Date: 2022.06.12

RE: Commentary Response per Permit No. 2112-250

This letter is in regards to your INITIAL review of the proposed single-family residence. Please see below for a response to your commentary in *italics* and our responses in **bold**. Thank you.

OPEN RISER STAIR - LOWER SECTION  
SCALE: 3/4" = 1'-0"

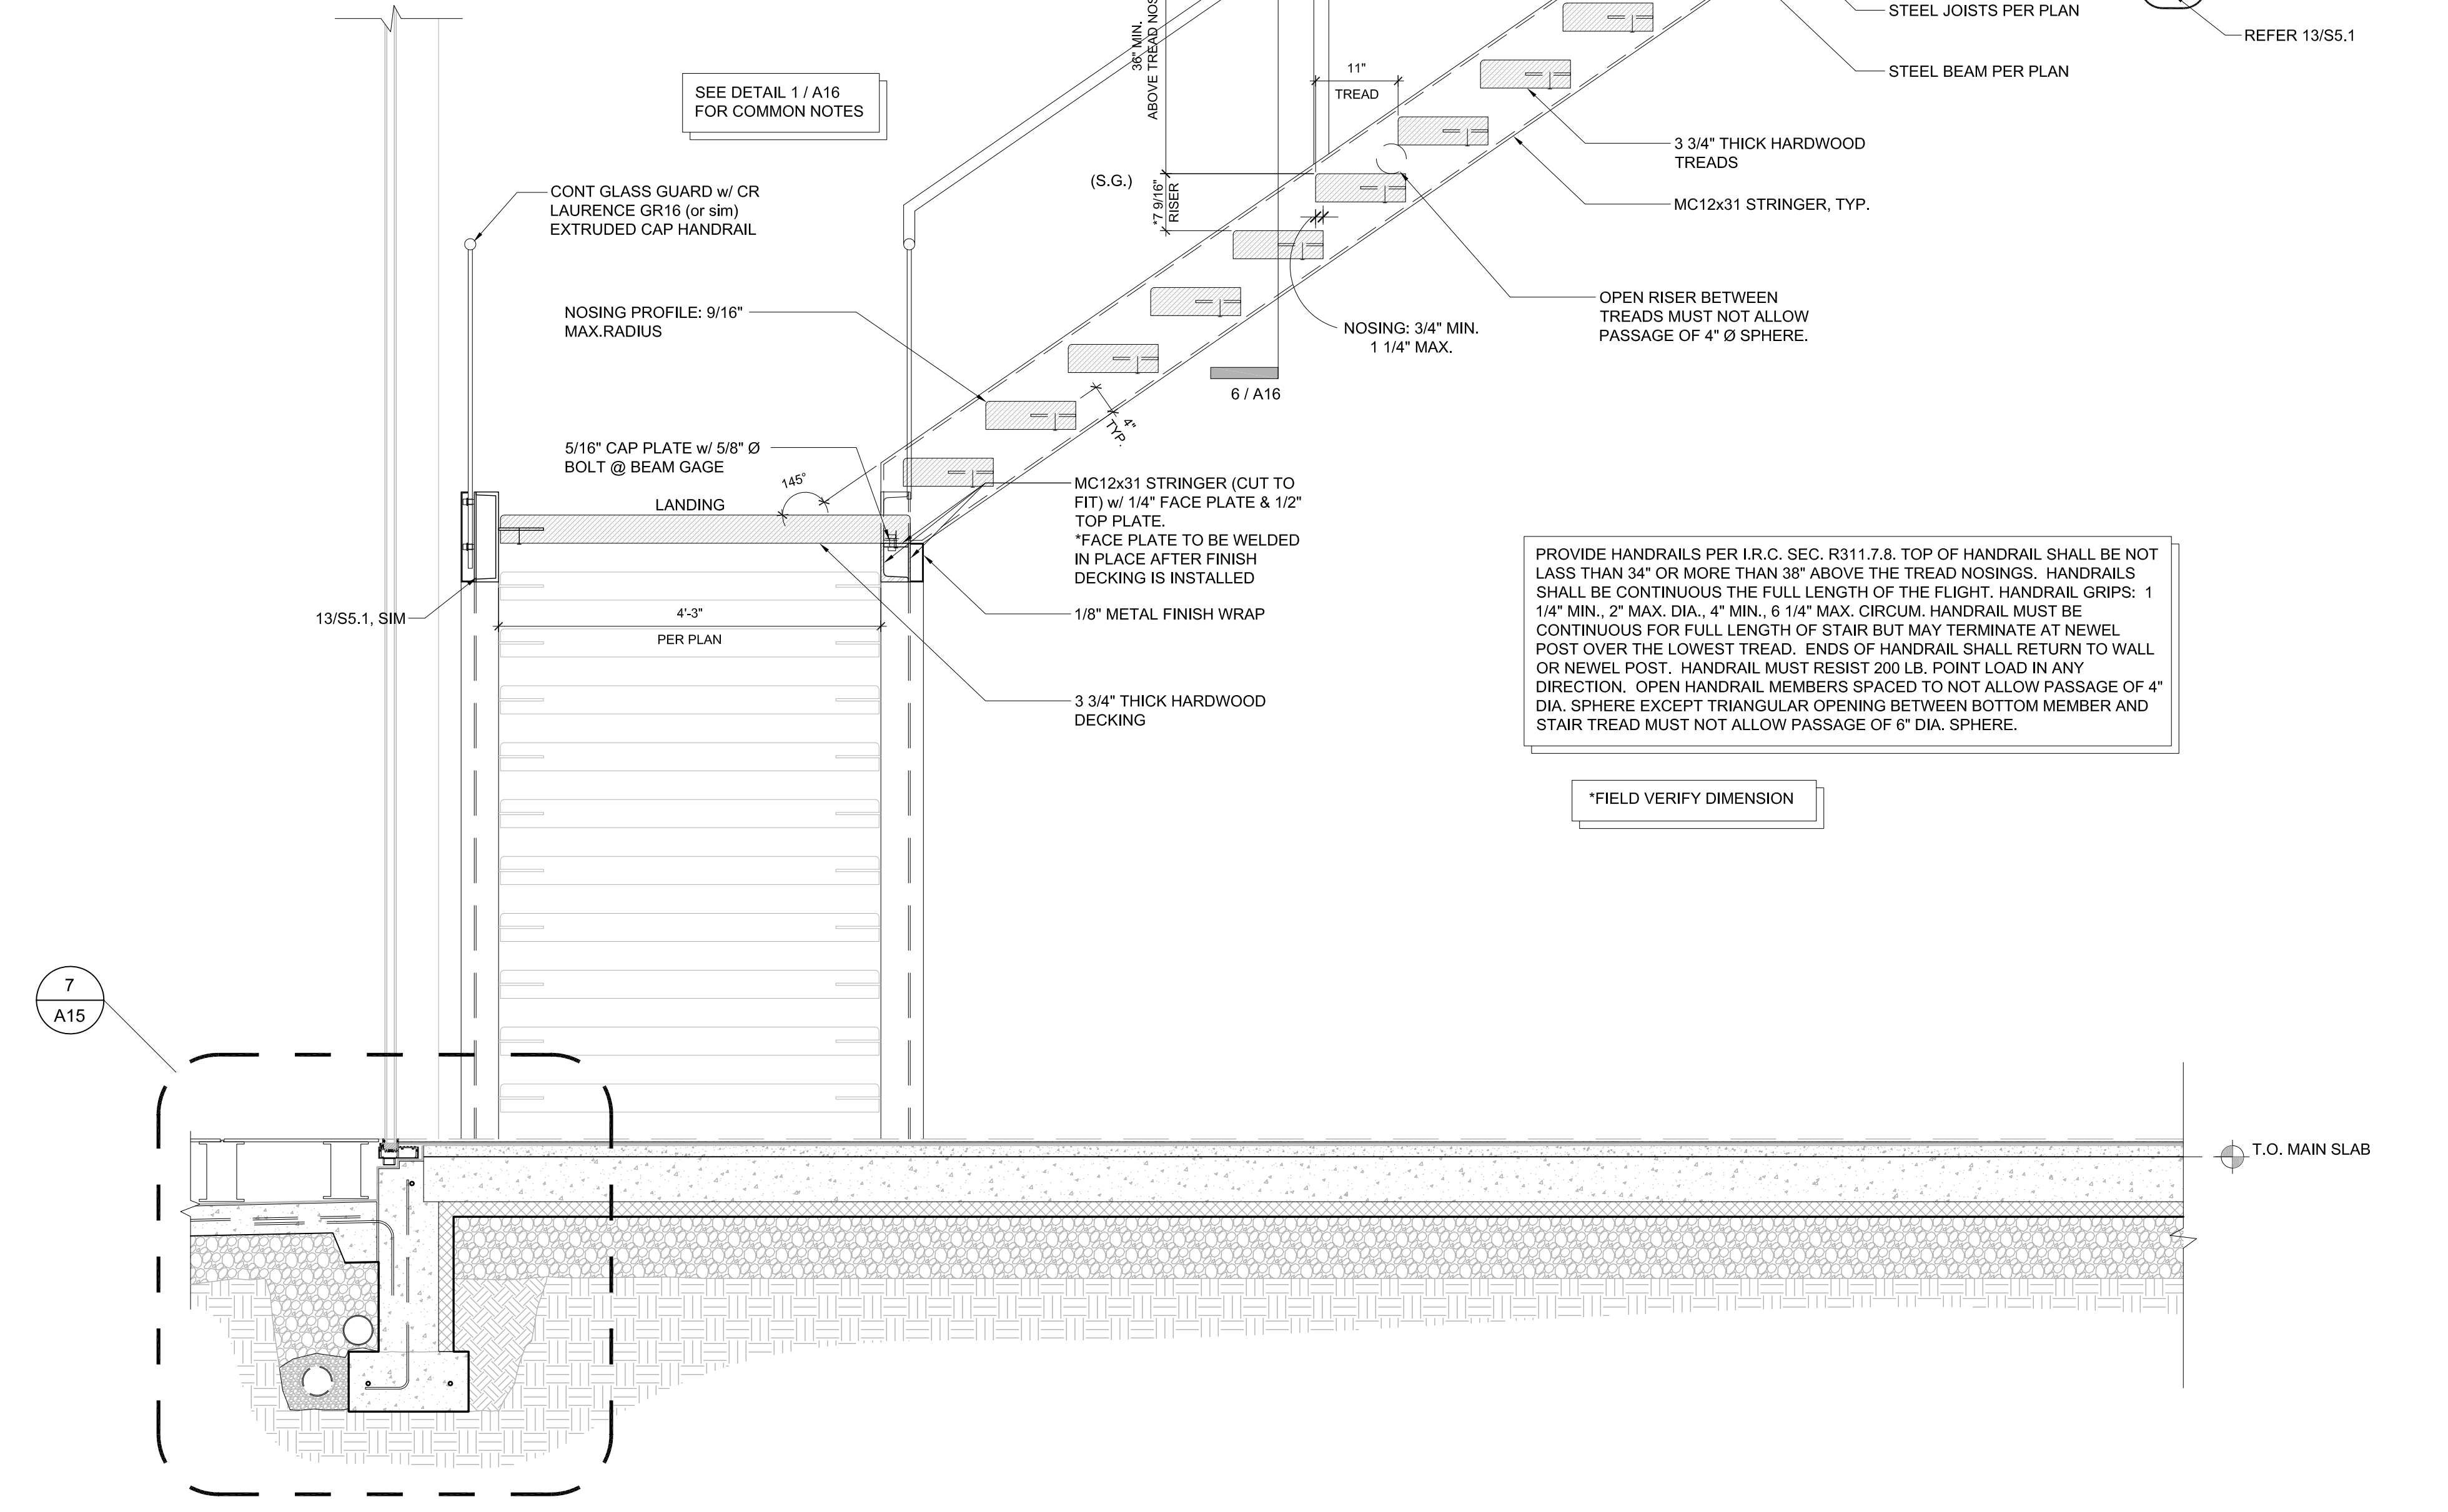
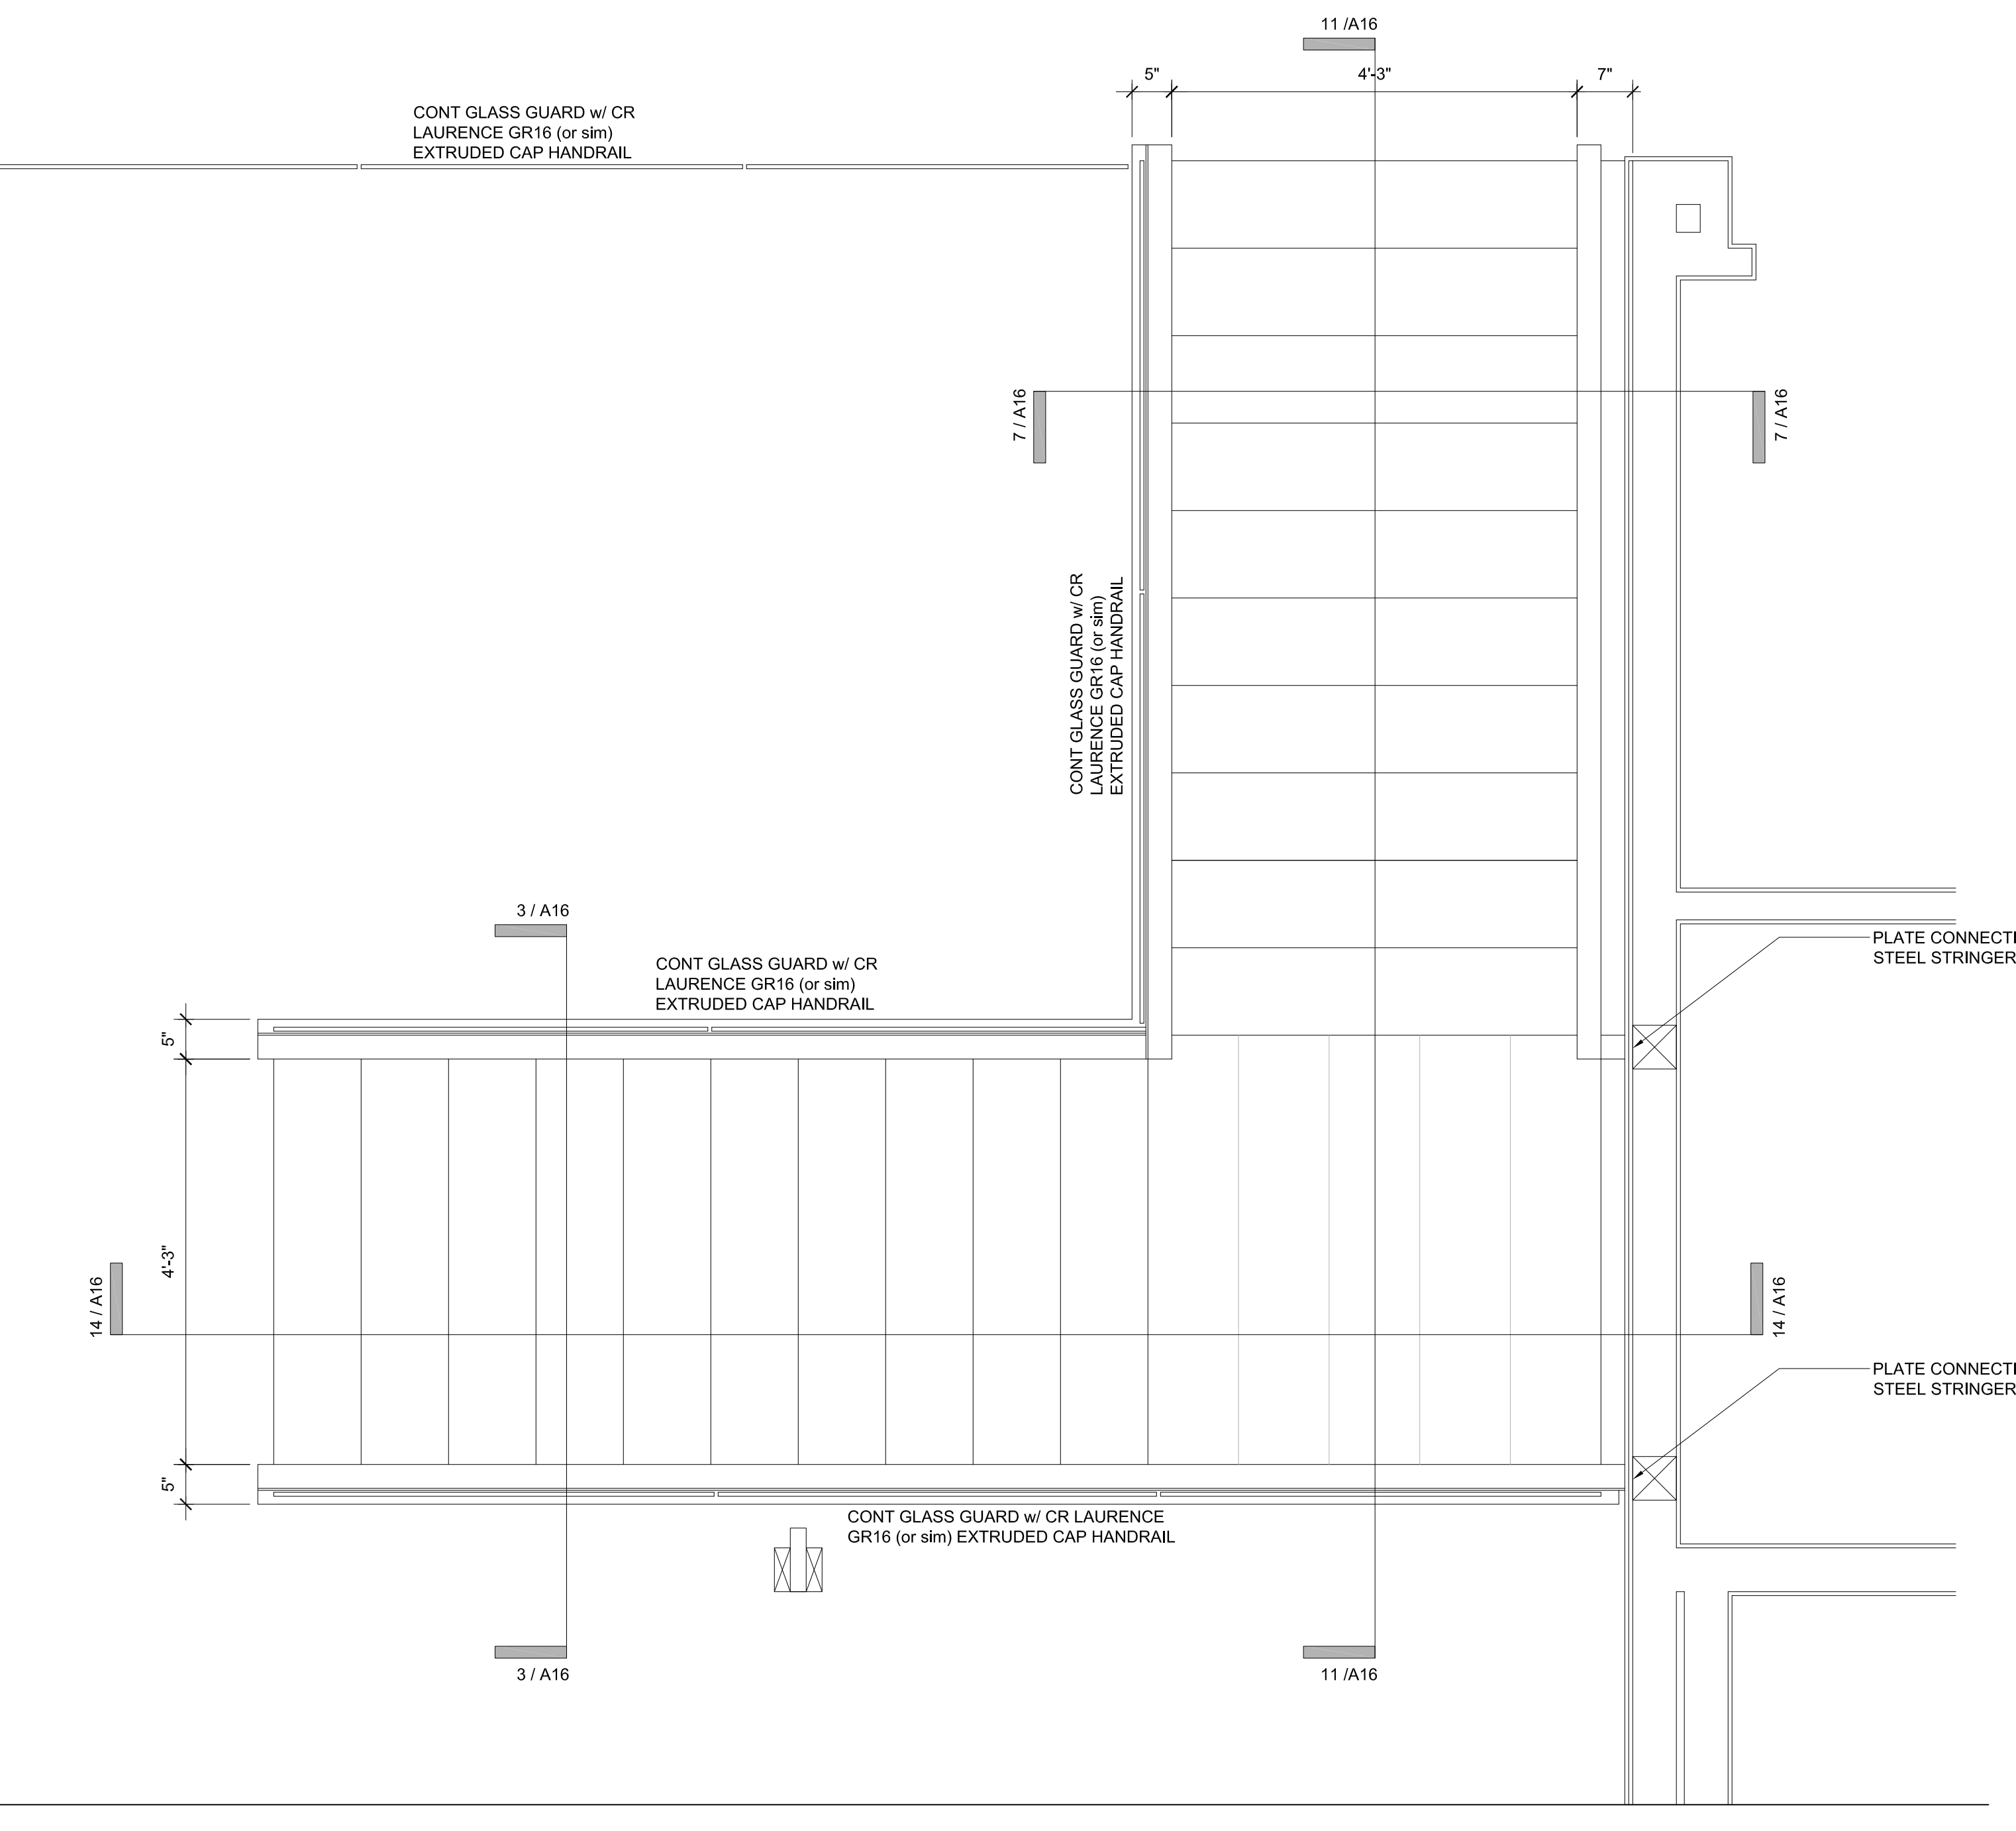
- 1. *Additional information needs to be provided at the interior stair Details on Sheet A16 indicate that handrails and guards will be provided and Detail 1/A16 shows basic information; however, we also find*

*frameless glass handrails and guards noted in plan. It is unclear where the handrails are actually intended. Provide specific information on the drawings. Additionally, better structural detailing needs to be provided to show connections of guards and handrails to supporting elements.*

- a. **Details, notes, and additional information has been revised. See applicable plan sheets, elevations, and detail sheets for further clarification per connections and detailing.**
